MINUTES OF THE DEVELOPMENT ASSESSMENT PANEL HELD

Proposal: 50 lot subdivision – details of this proposal have been previously discussed with Manager Development Assessment and the purpose of this meeting was to clarify Council's resolution of 17 May 2000.

Meeting Notes – Planning Focus Meeting
Tweed Heads Civic Centre
11 May 2004
Proposed 80 Lot Subdivision and Master Plan under SEPP 71,
Walmsleys Road and Stott Street, Bilambil Heights

**Re: 85 lot residential subdivision, Walmsleys Road and Stott Street,
Bilambil Heights - MP05-0198**

Figure 1 – Site Location and Zoning
Source: Figure 1 of Environmental Assessment, DAC, November 2006

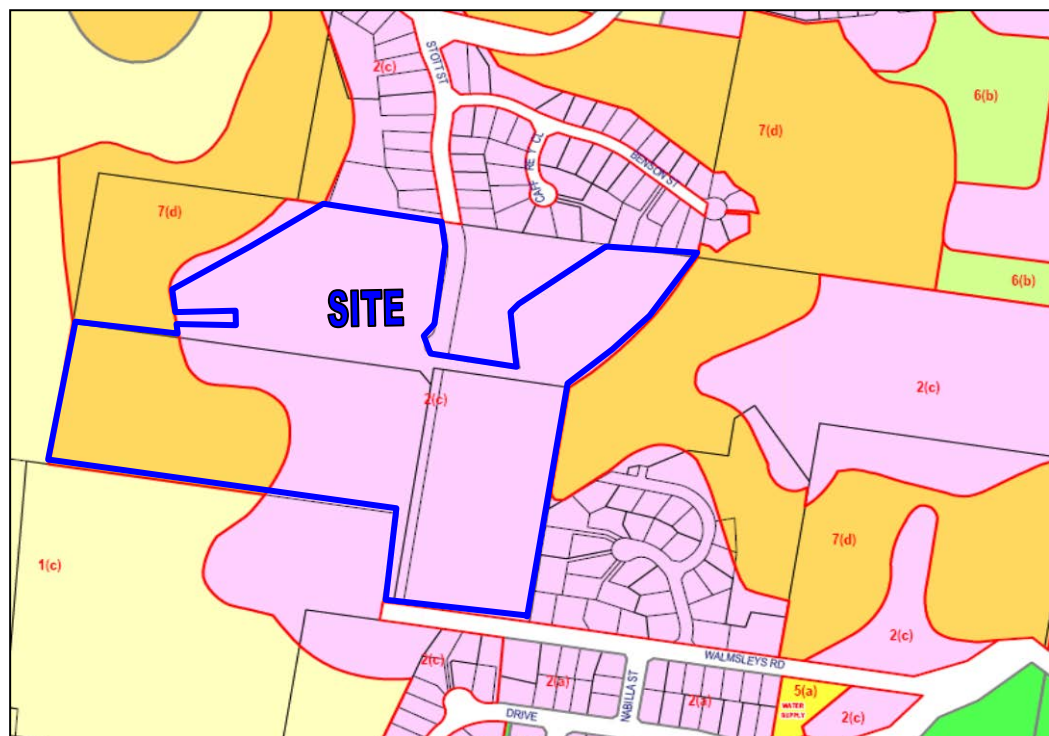
The site boundaries should be indicated on Figure 1. Also the full extent of the eastern portion of the site should be shown.
